**From:** [REDACTED]  
**Sent:** 19 May 2025 12:49  
**To:** Planning  
**Subject:** re: Planning Application No: 3/2025/0305

I'm writing in connection with the above planning application at 36 Painter Wood.

drawing title:  
PROPOSED SITE PLAN

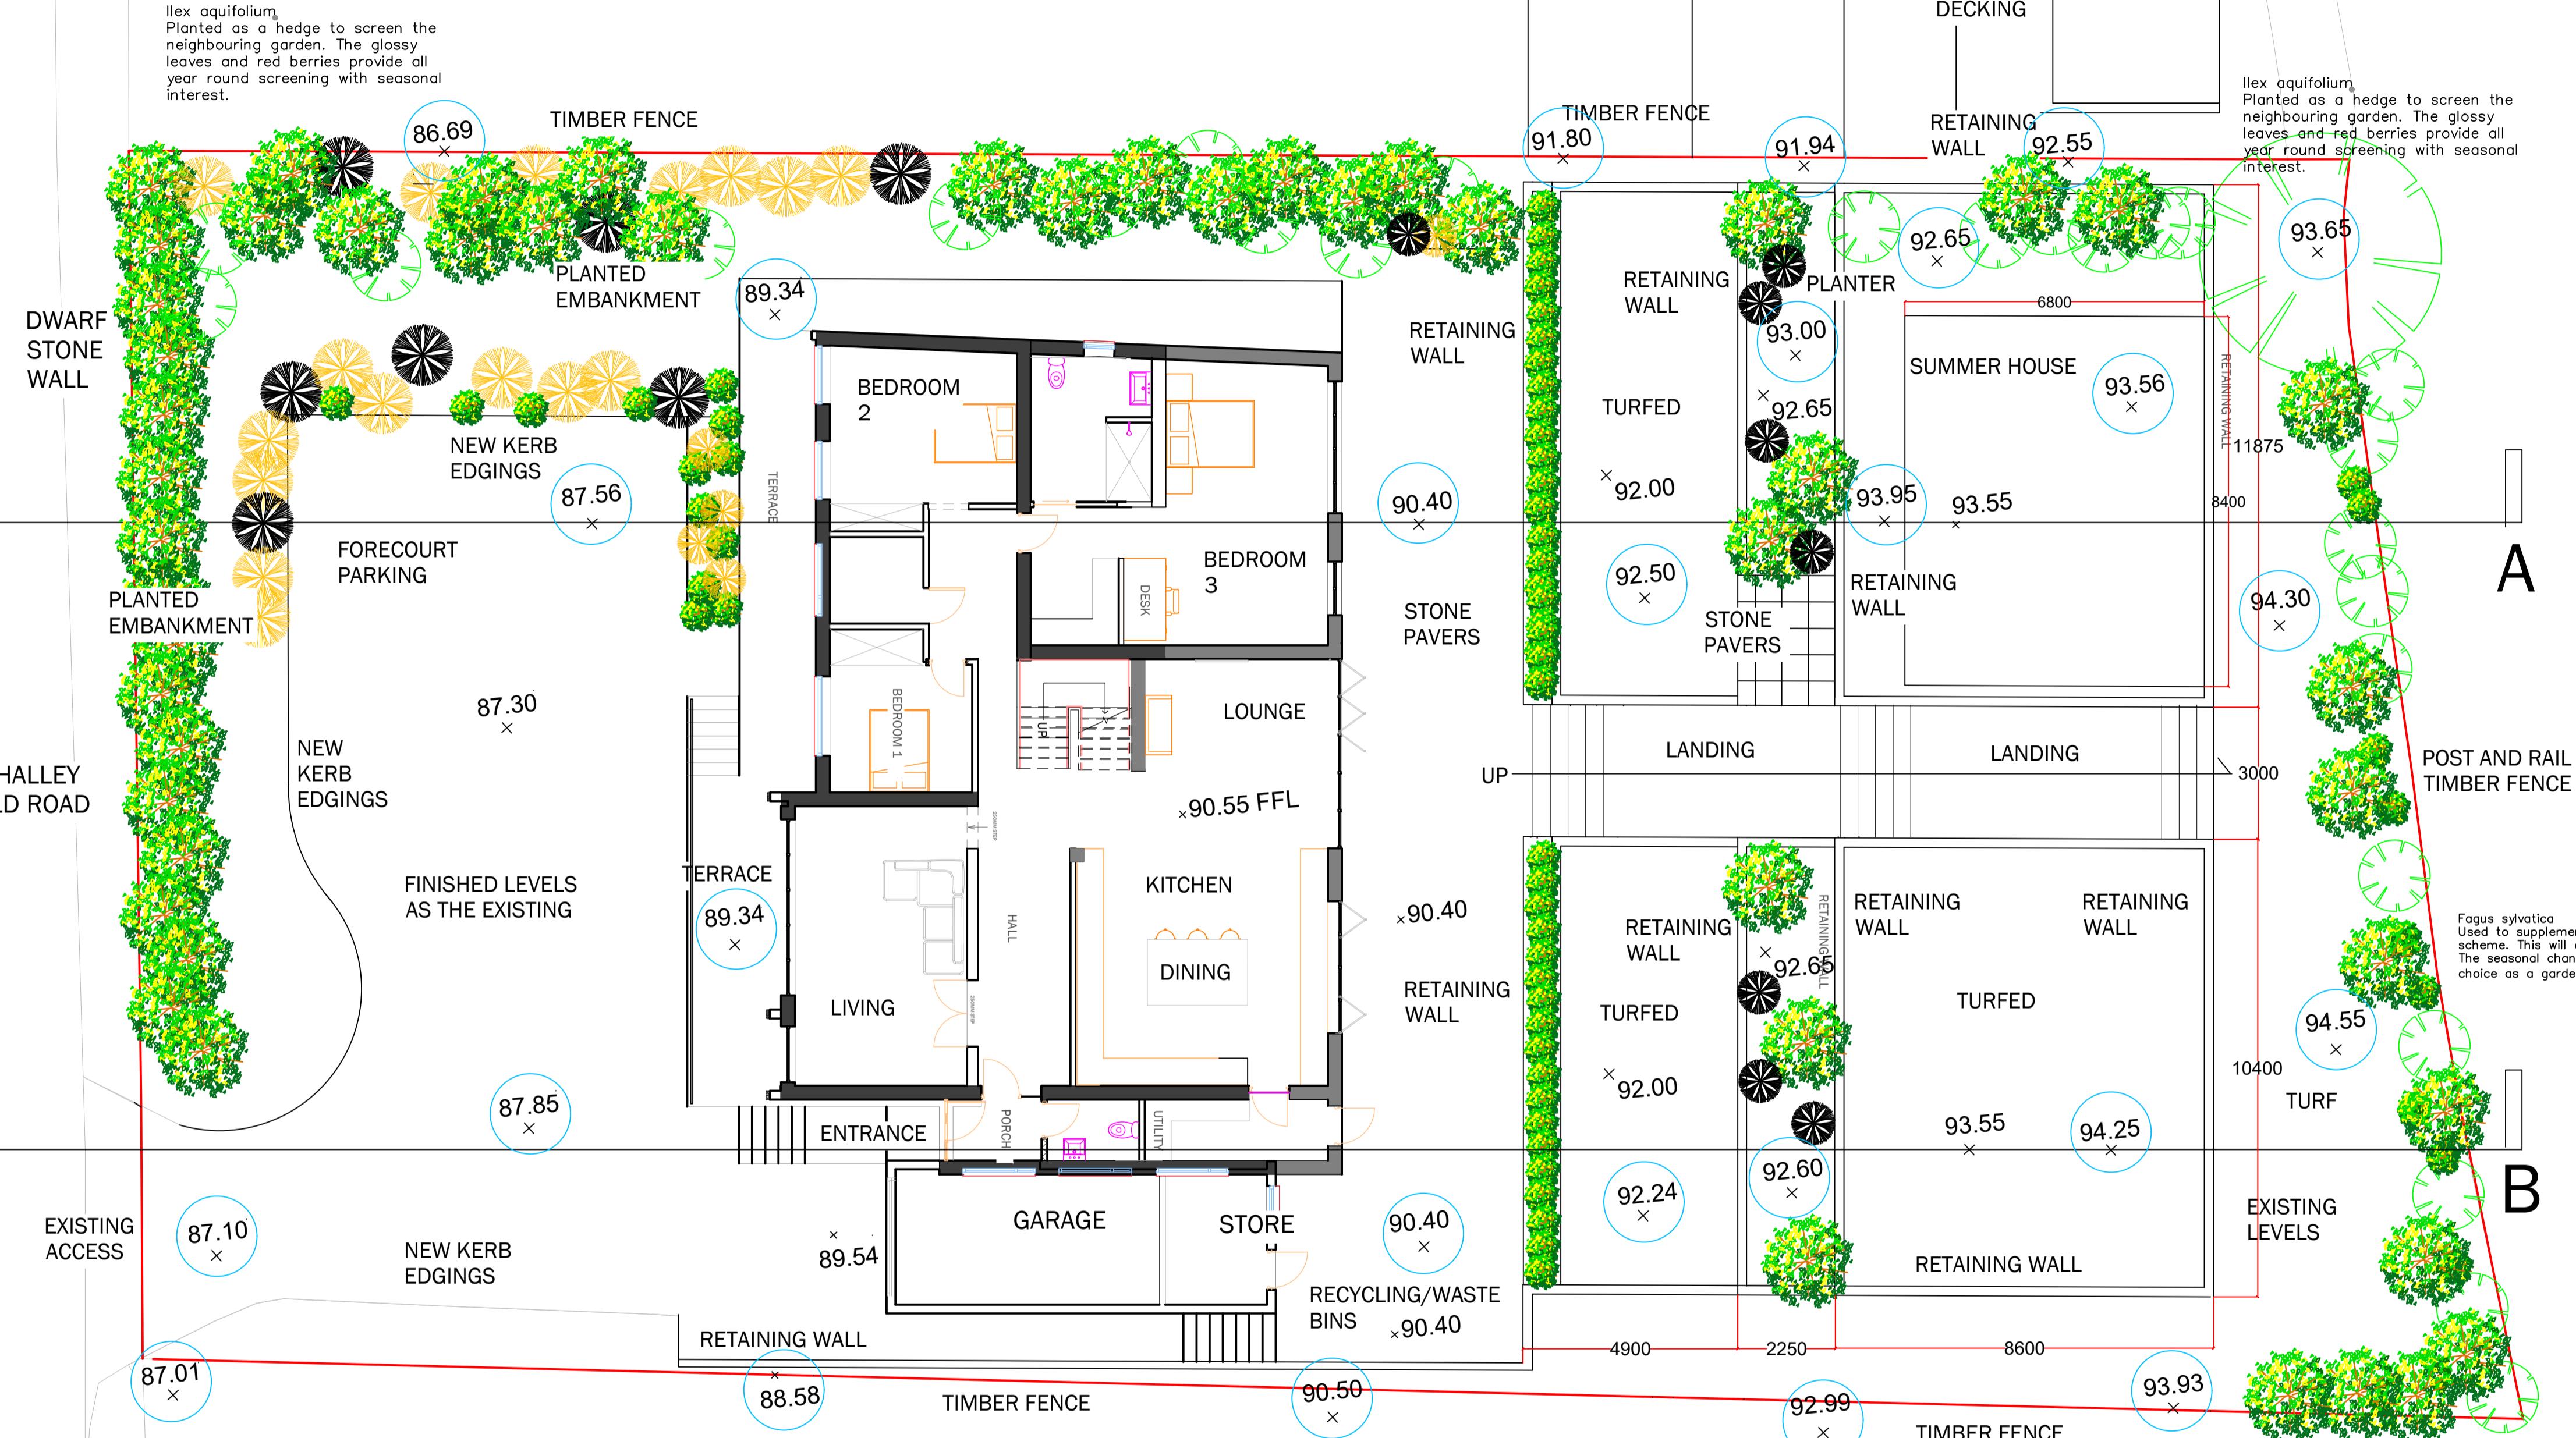
I have no objections to the external landscaping & engineering works scheme but seek clarification on how the planted embankments will be retained along the boundary with [REDACTED] Painter Wood.

Proposed summer house design

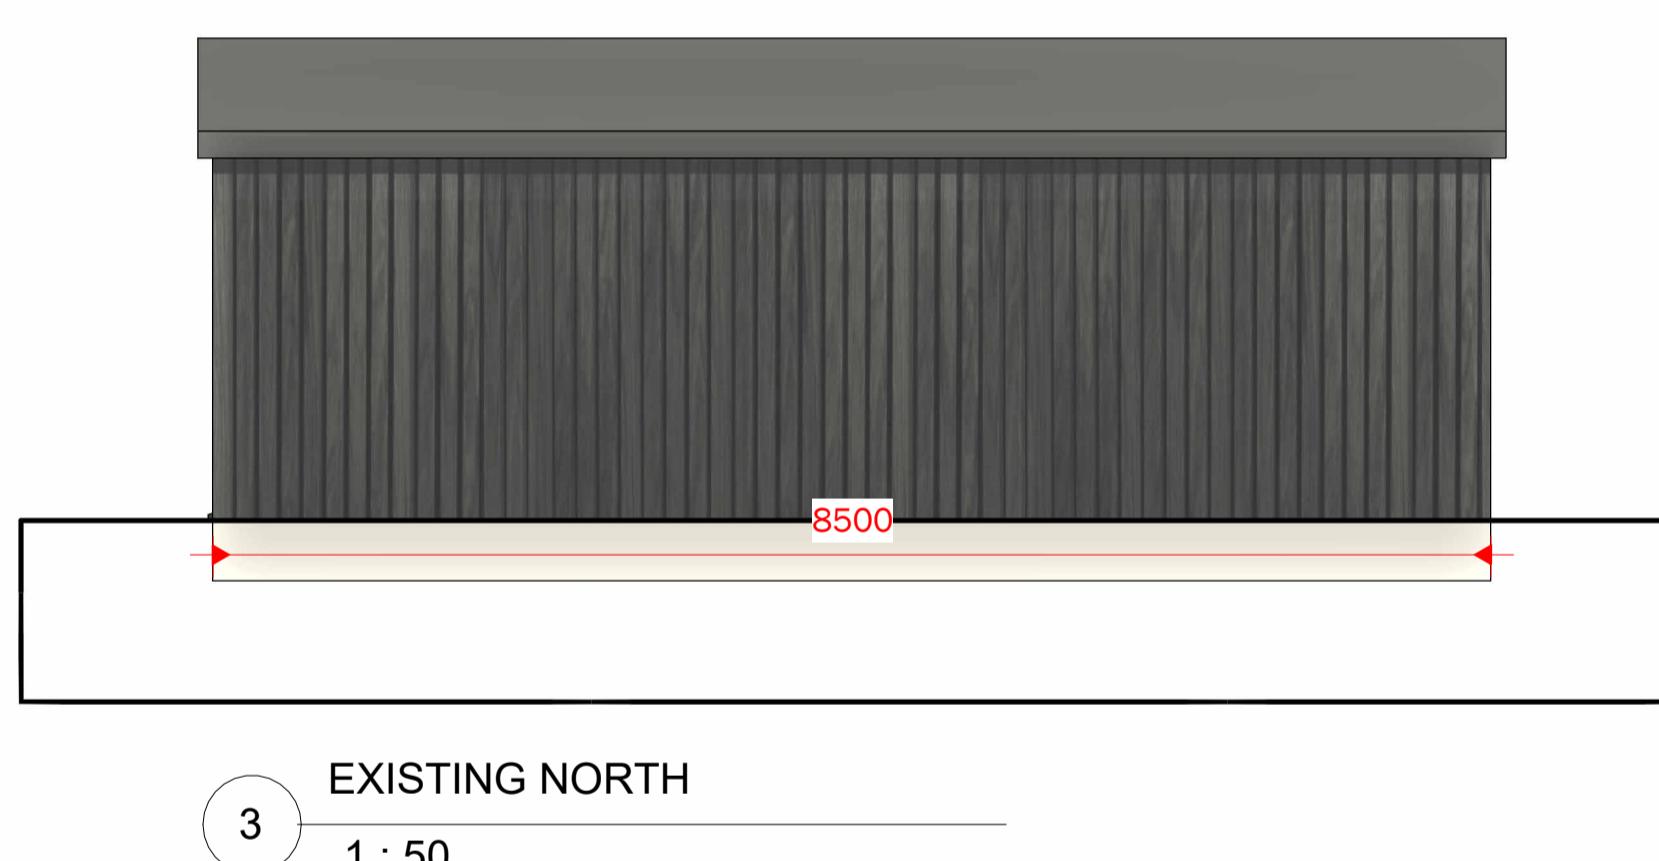
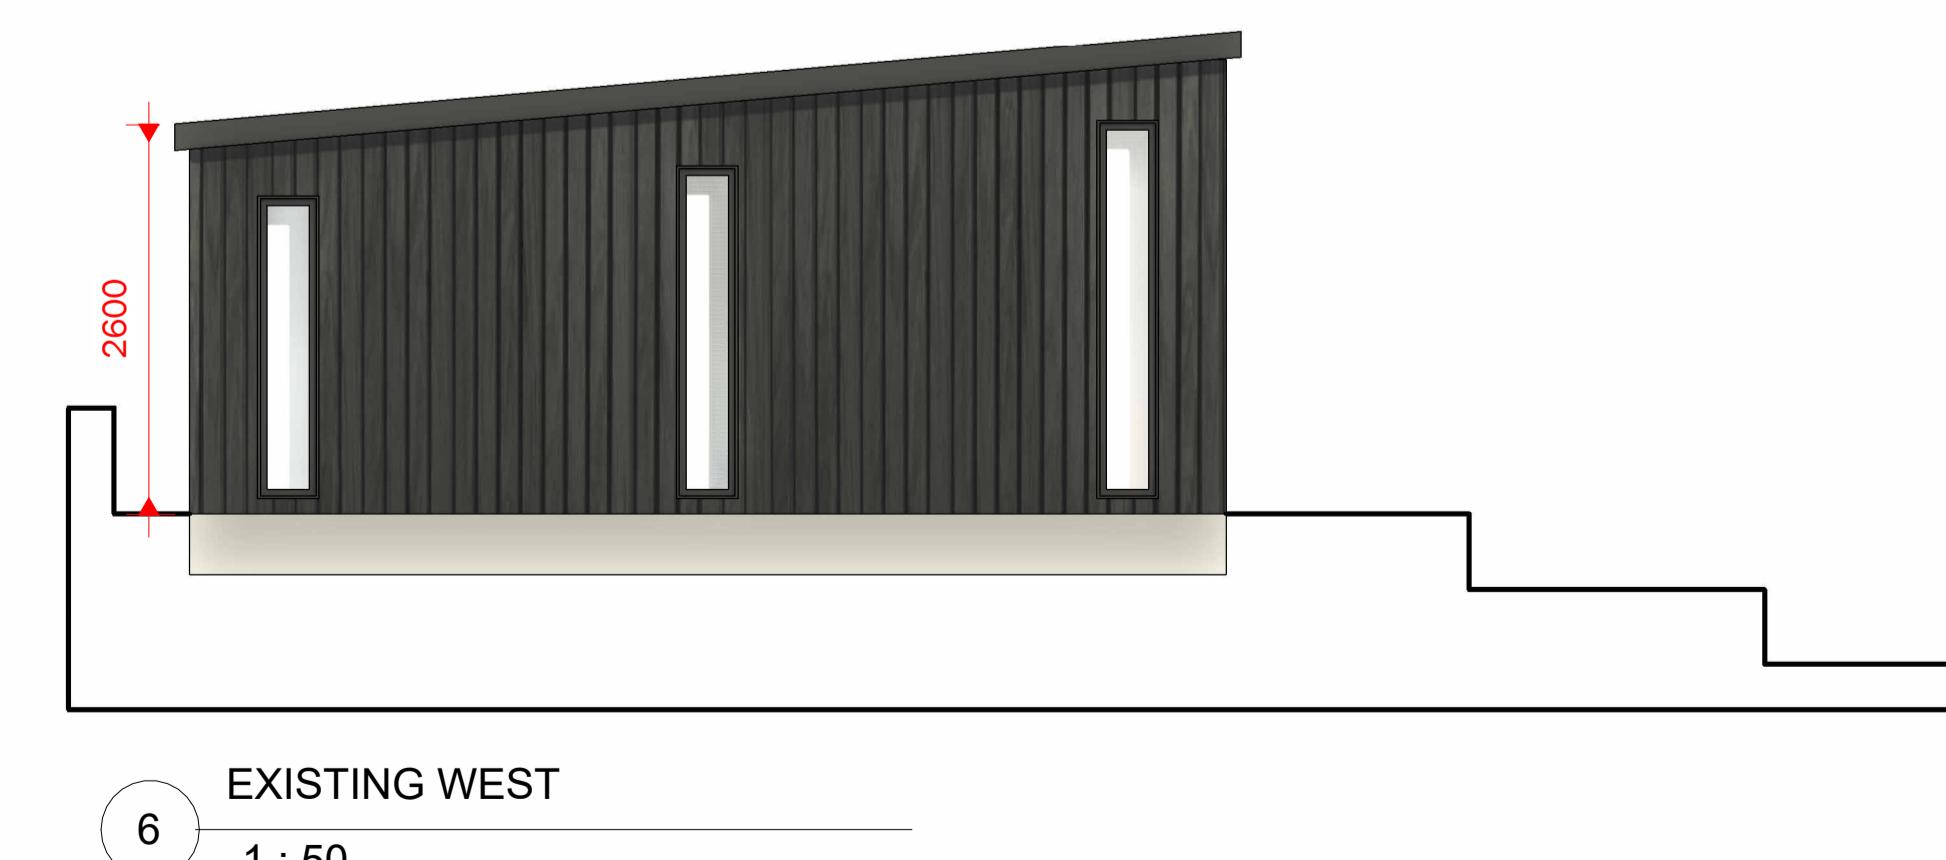
We object on the grounds that the glazing to the West and South elevations [REDACTED] [REDACTED]. I have [REDACTED] or [REDACTED] remove this glazing but for the avoidance of doubt I want to register my objections to these elements.
